Our Ref: SDNP/20/04469/ADJAUT
Contact Officer: David Easton

Neighbouring Authority Consultation

Proposal: Adjacent Authority Consultation - FG/123/20/PL - Demolition of a polytunnel, storage building & scaffolders' shelters & racking, use of land for Class B8 container self-storage & the siting of 79 No. single-stacked storage containers, part regrading of the ground, new fencing, CCTV & lighting. This site is in CIL Zone 3 (Zero Rated) as other development & is a Departure from the Development Plan.

Address: Land at Former McIntyre Nursery , Littlehampton Road , Ferring , BN12 6PG

TITLE
PROPOSED SITE & BLOCK PLAN

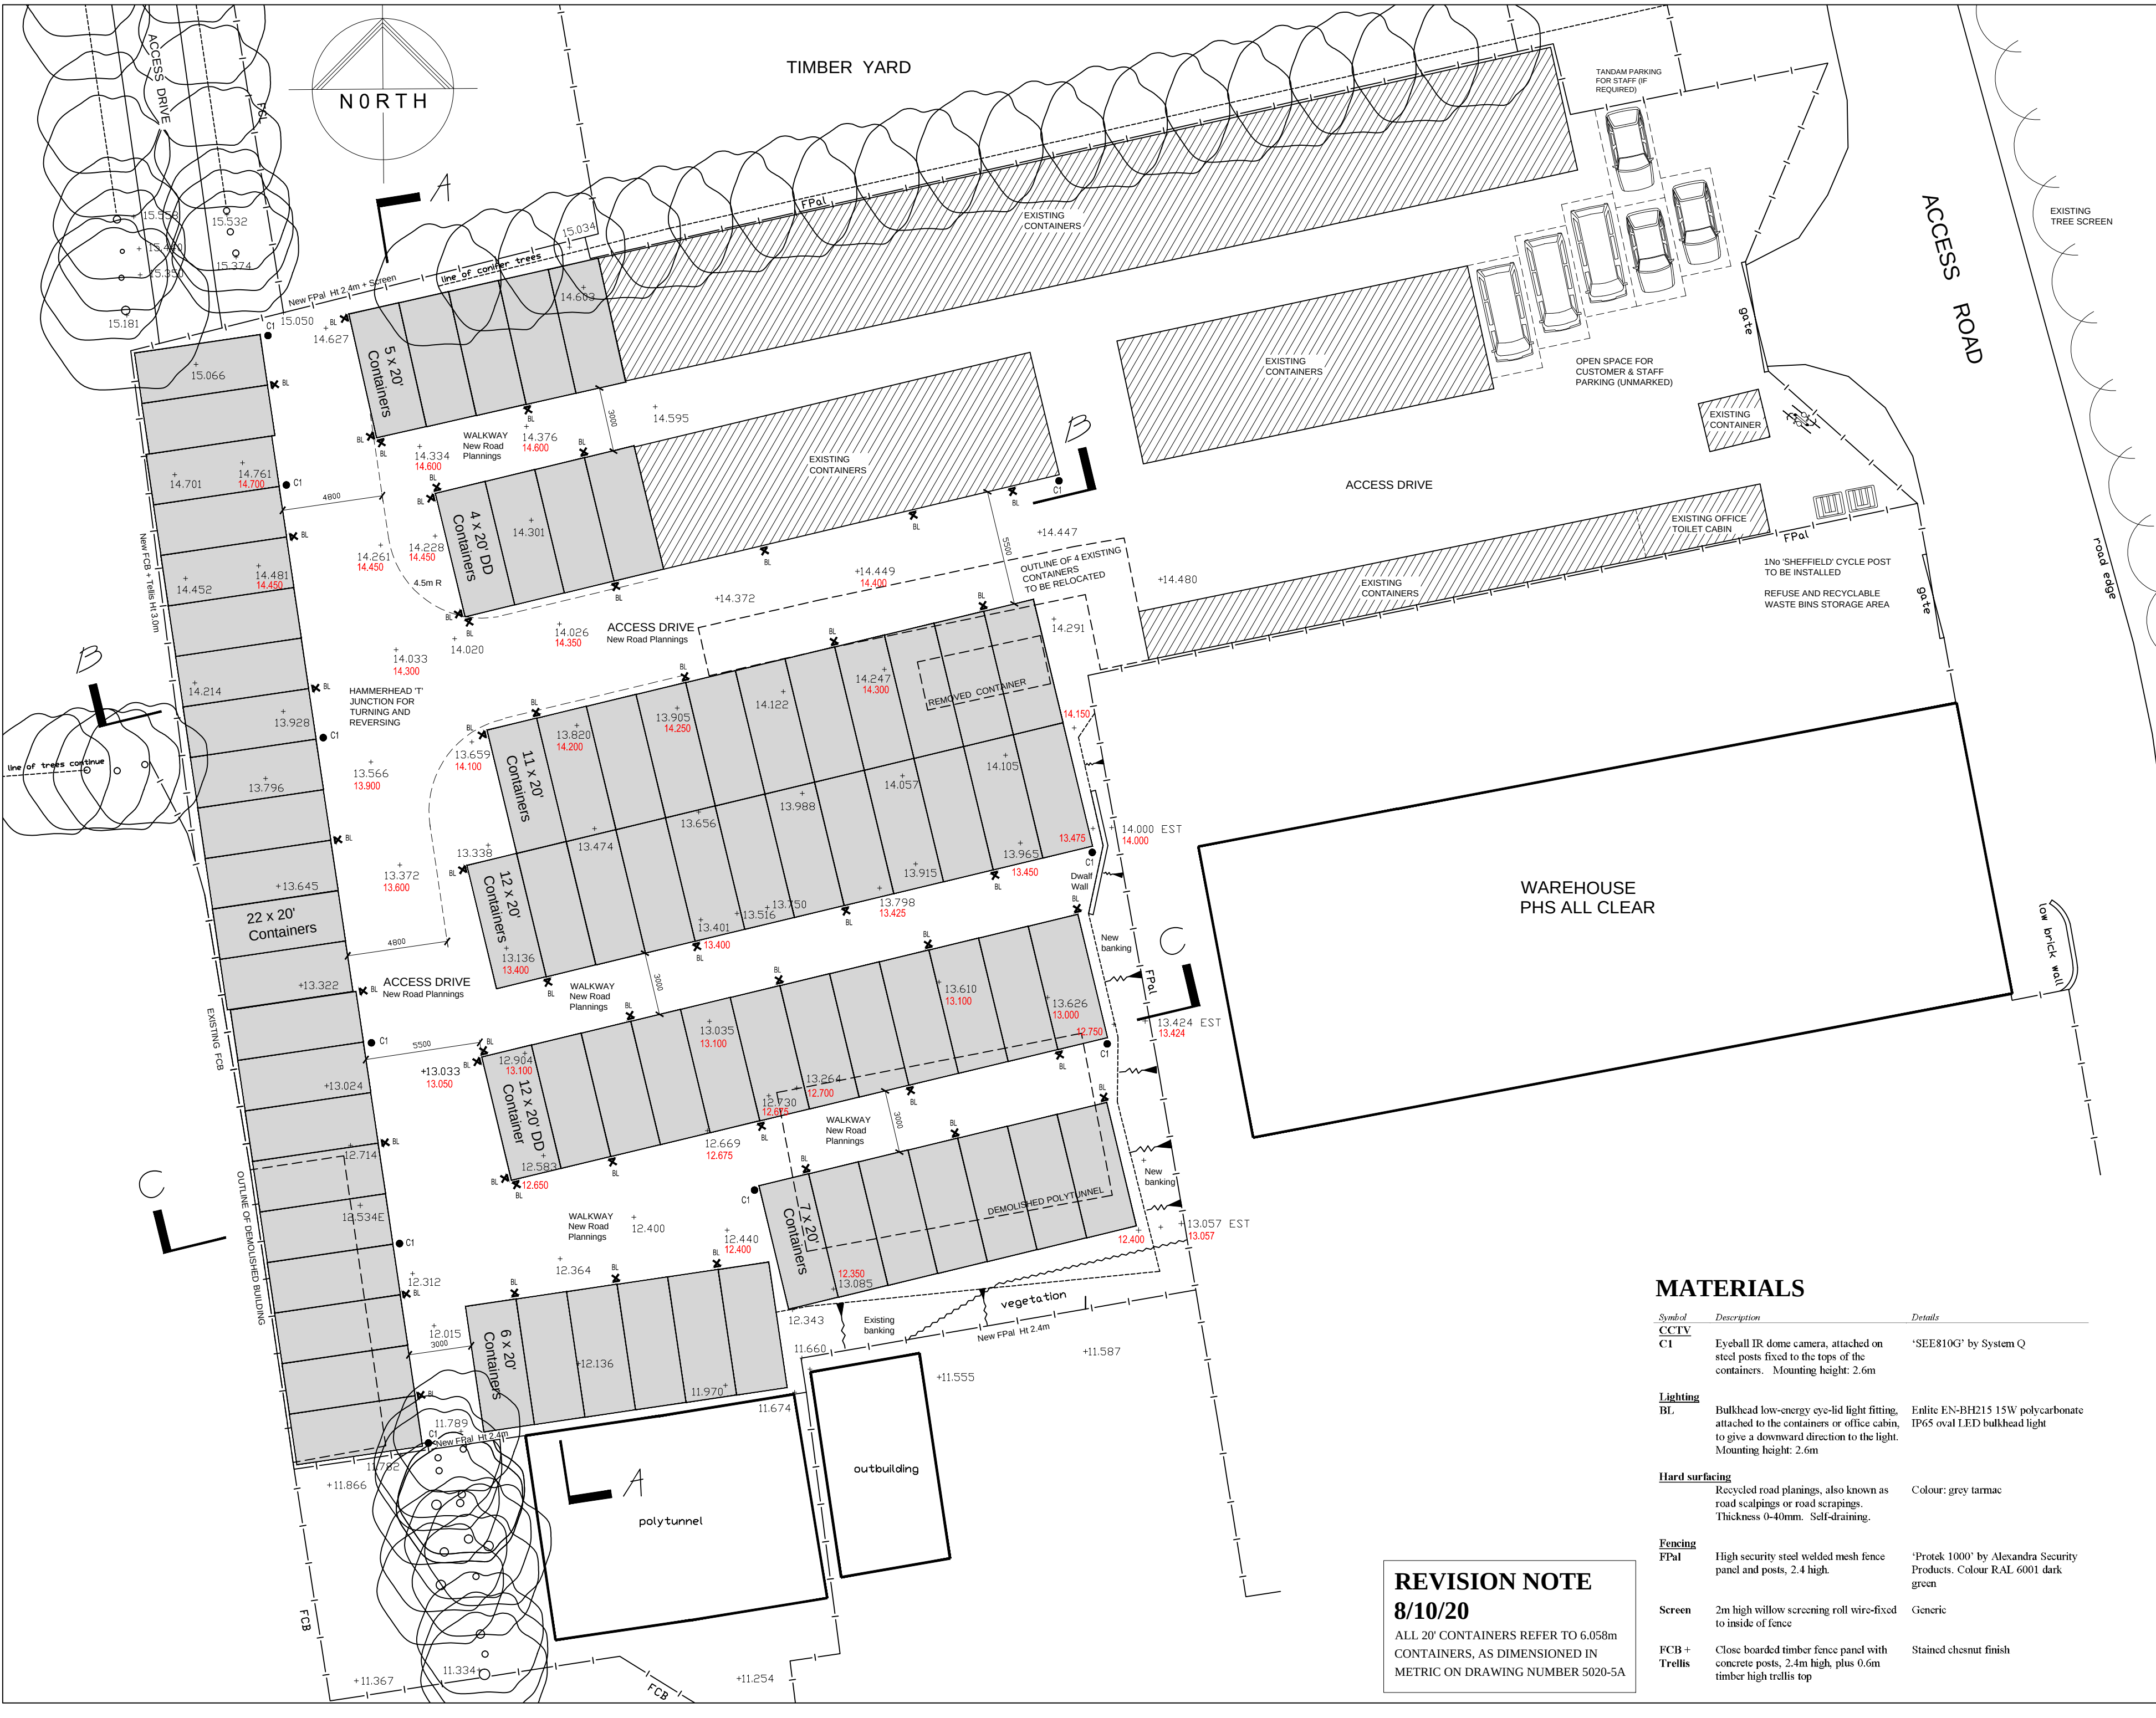
The South Downs National Park is a designated International Dark Sky Reserve and dark skies and tranquillity are a special quality of the National Park which need to be protected. Paragraph 180(c) of the NPPF outlines that development should limit the impact of light pollution on intrinsically dark landscapes and nature conservation. The site is located adjacent to the Dark Skies Transition Zone (E1b) and it is important to reduce light pollution in these areas as they have the potential to become dark zones in the future.

Therefore, measures should be incorporated to control light spill and any form of flood lighting should be avoided, with no external lighting other than motion sensor security lighting that complies with Dark Skies requirements. Further information/advice on sensitive lighting can be found in the SDNPA's Dark Skies Technical Advice Note 2018 which is available at the following link:
